Online Comment

Application H11-0128-23
Location Land to Rear of 45-47 Bridge Road Long Sutton Spalding PE12 9EF
Proposal Demolition of existing commercial buildings and erection of new office, admin buildings and workshops (B2) to accommodate the relocation of Tears Recovery

Name Sue Armour
Address Team Leader Environmental Protection SHDC

Drawing Title: PROPOSED BUILDING ELEVATIONS/PLANS
Drawing No: 4485K03 Revision: C

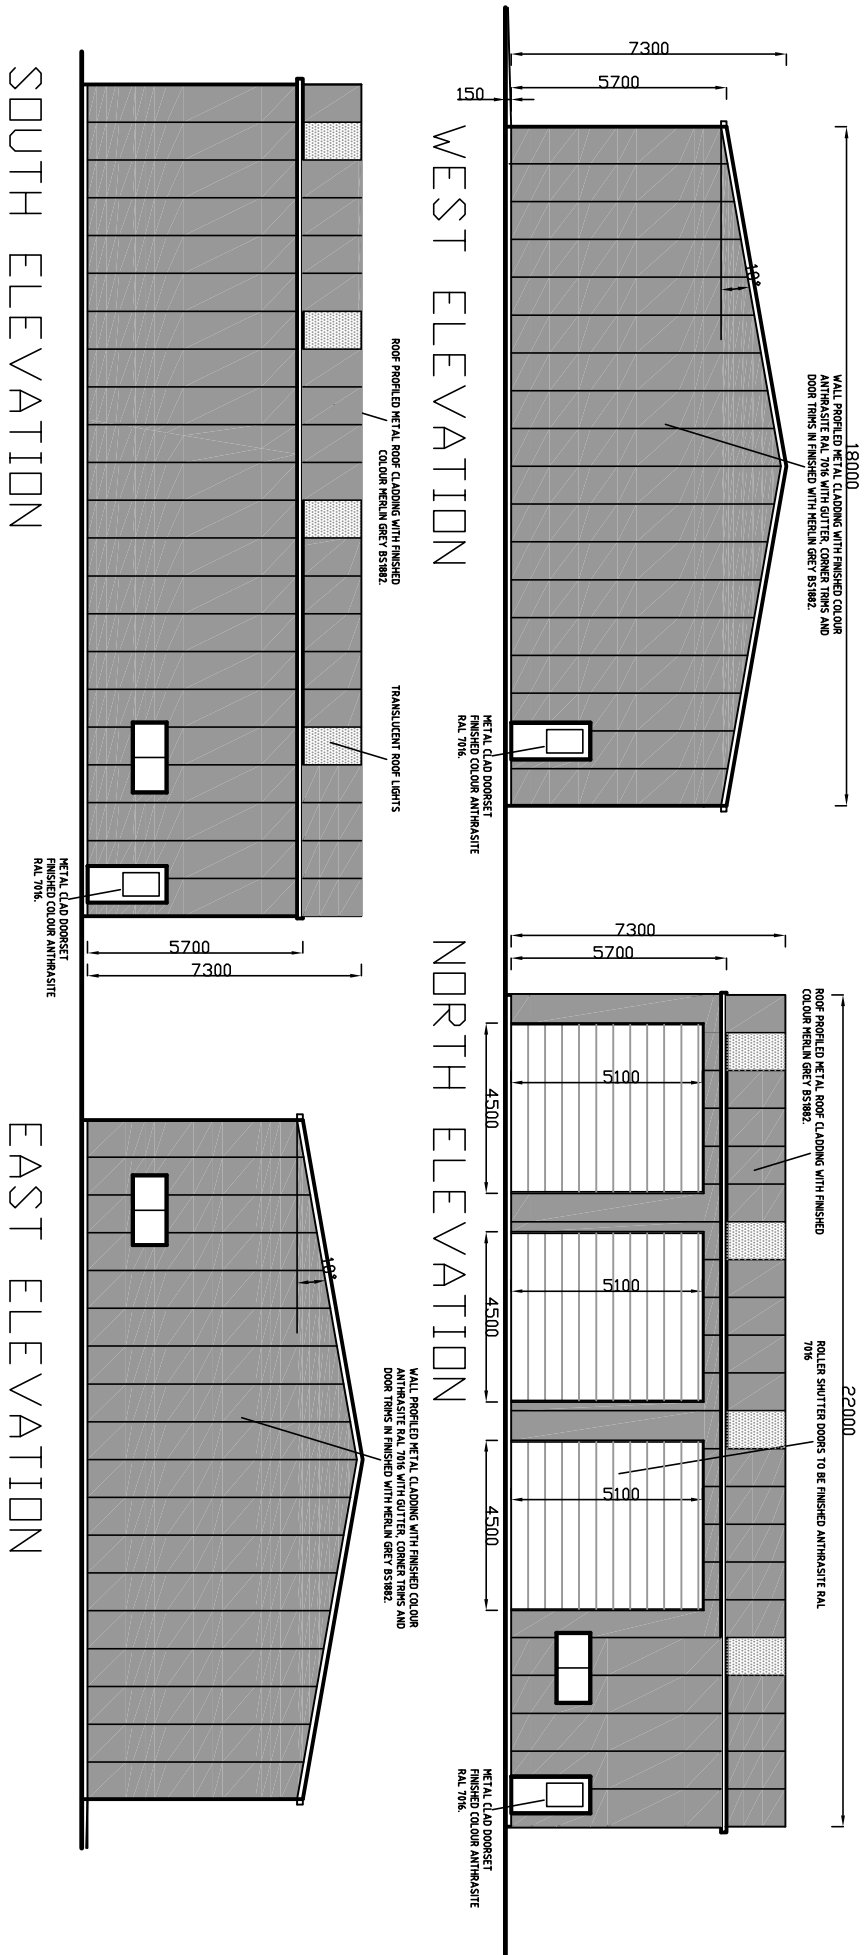
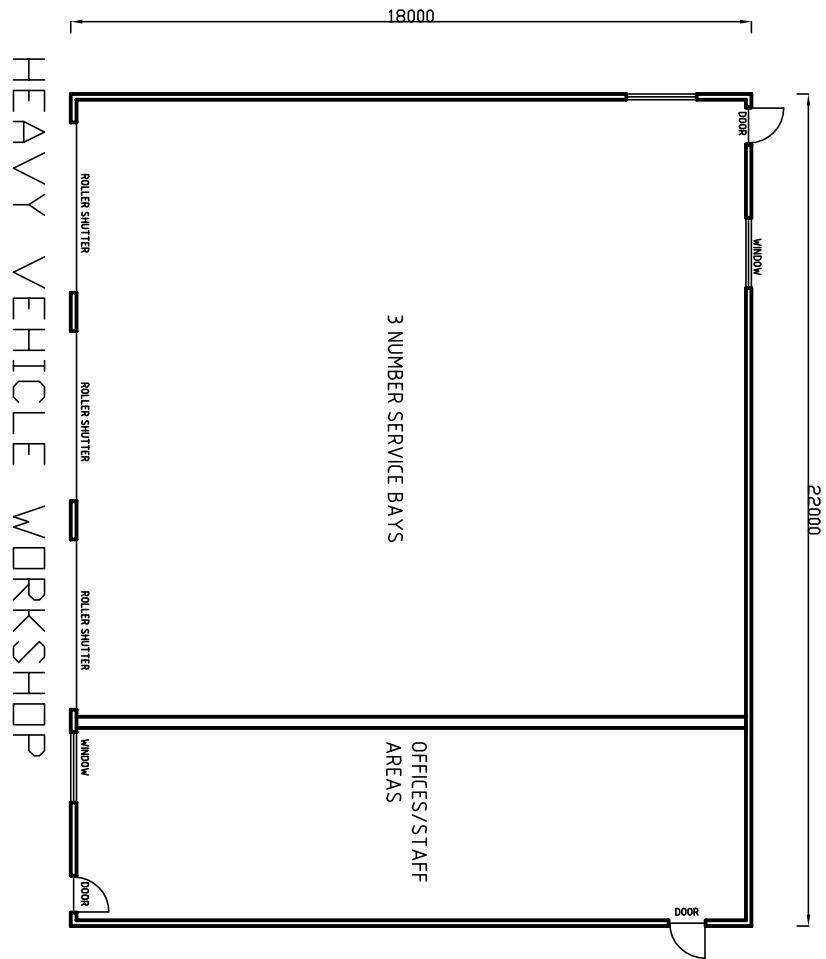
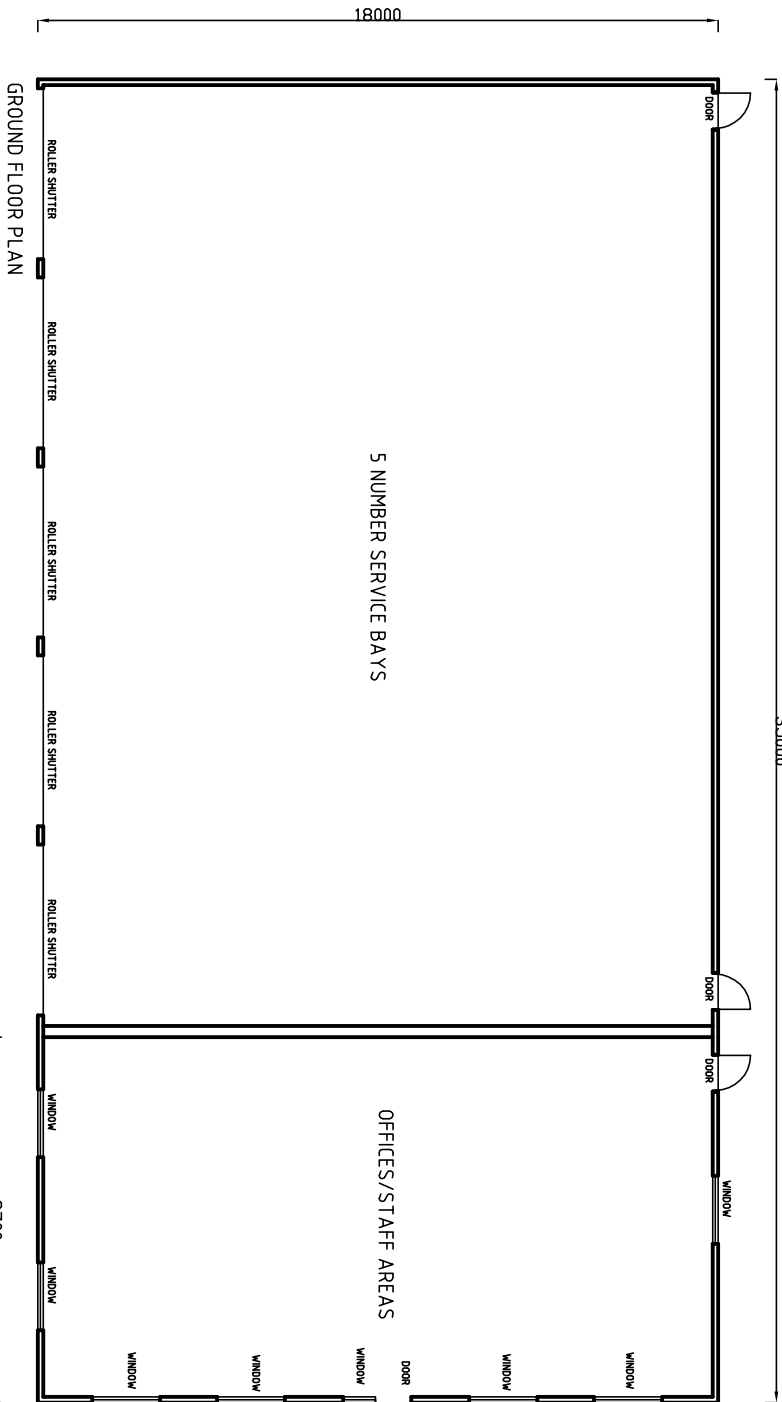
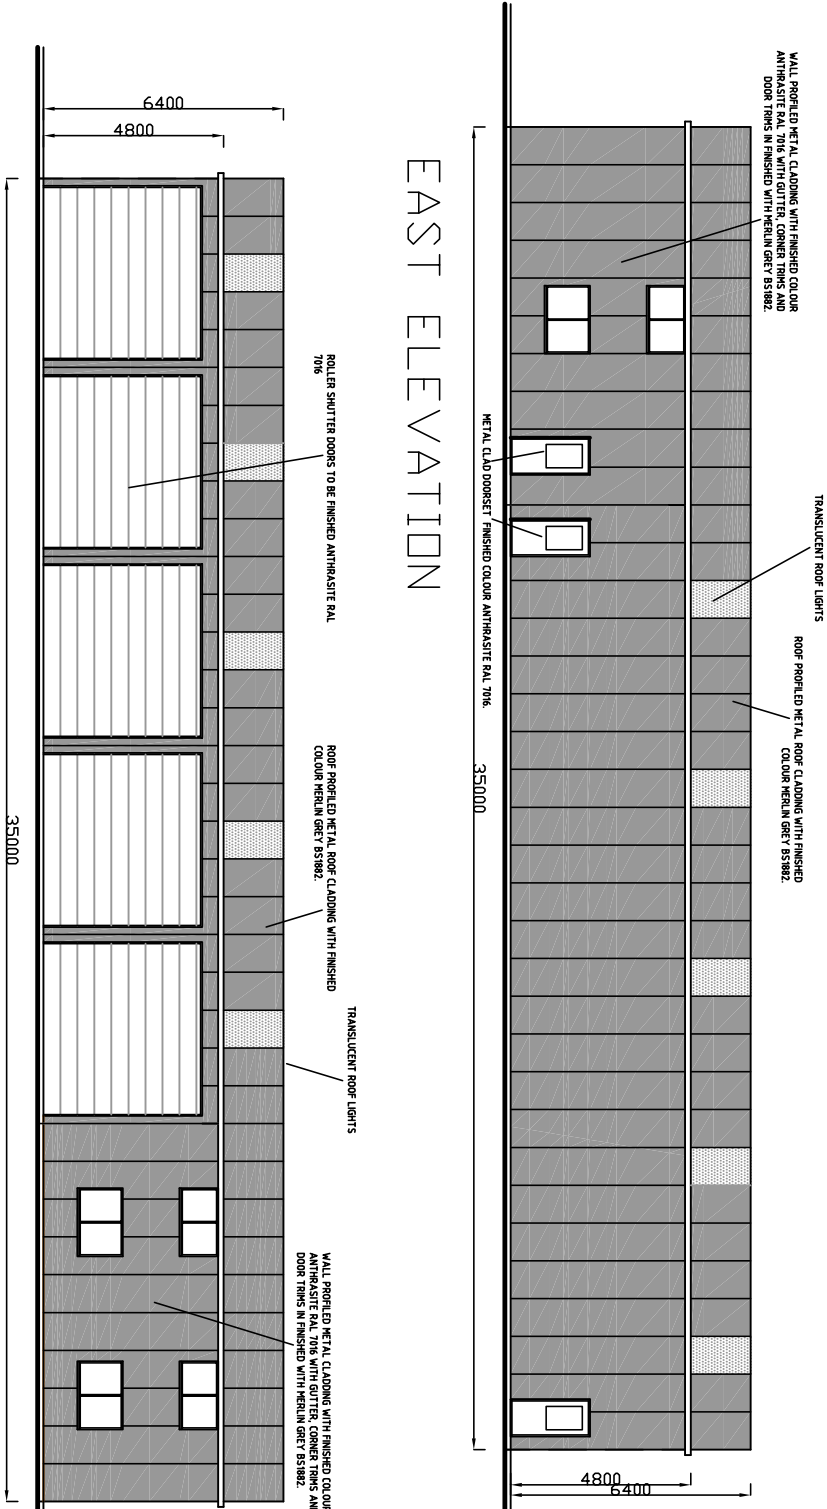
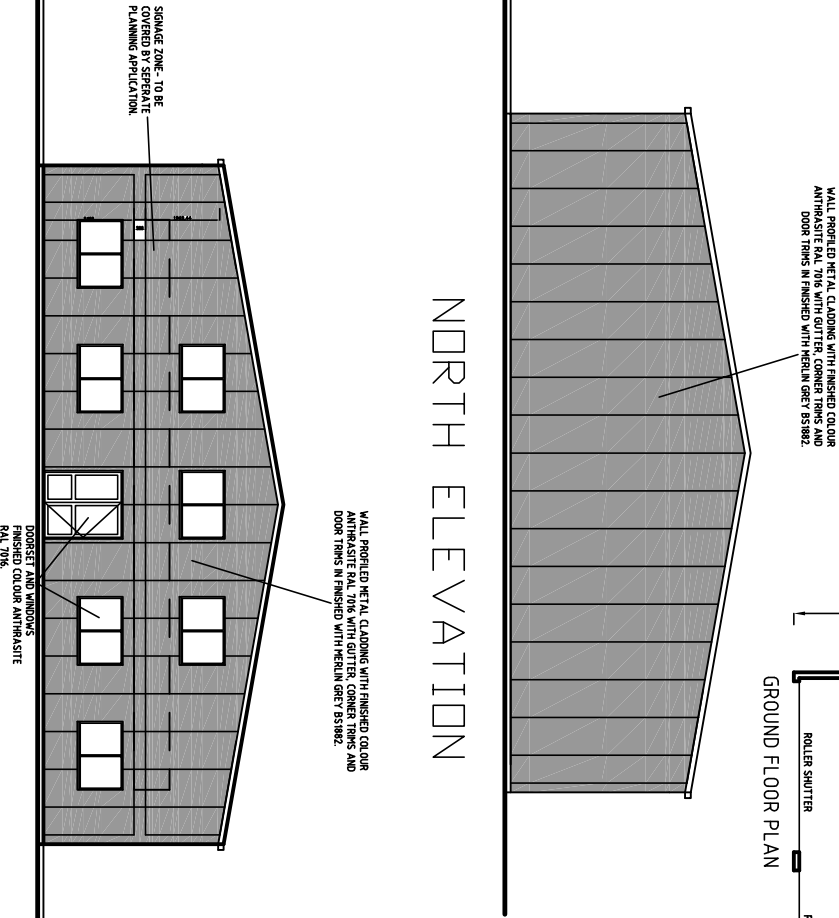
- 24hr working in close proximity to residential properties may give rise to a significant adverse effect on nearby residents.
- Use of the workshop during the evenings may give rise to an adverse effect on nearby residents.

There are no noise mitigation measures proposed and so the application in its current form does not demonstrate that a good standard of amenity can be achieved for nearby residents.
